**From:** Jim Guest  
**Sent:** 11 October 2019 12:15  
**To:** James Kirkham  
**Cc:** DC Support  
**Subject:** 19/01148/F 19/01149/LB - North Arms Inn, Wroxton

**Jim Guest**  
**Environmental Protection Officer**

Drawing No
2016-34/06F

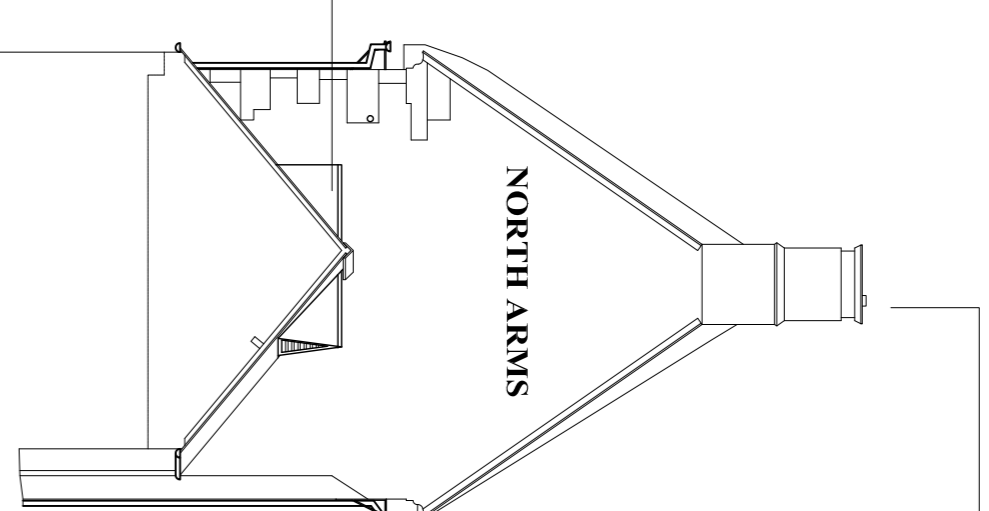
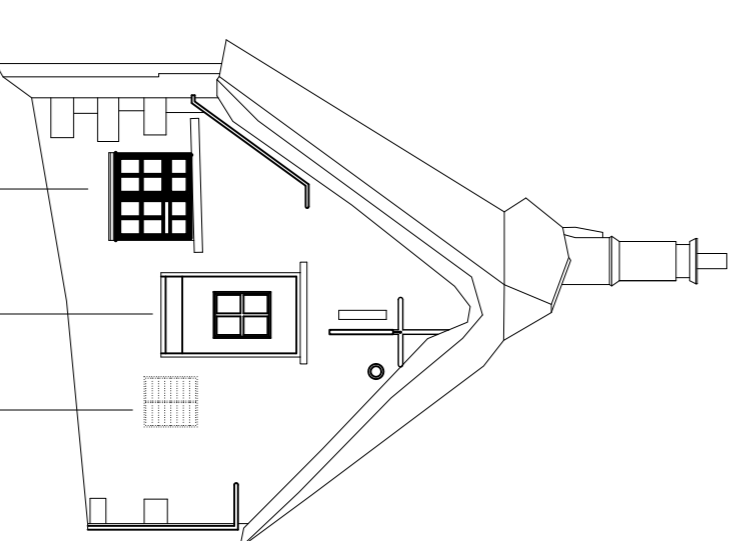
The new plan for the extracts to route through the existing gable chimney should ensure the emissions are discharged above ridge height and minimise the impact of any kind of odour or noise to neighbouring properties. However, we would still like to see the detailed design confirming the full size and details of the extract system when it is submitted.
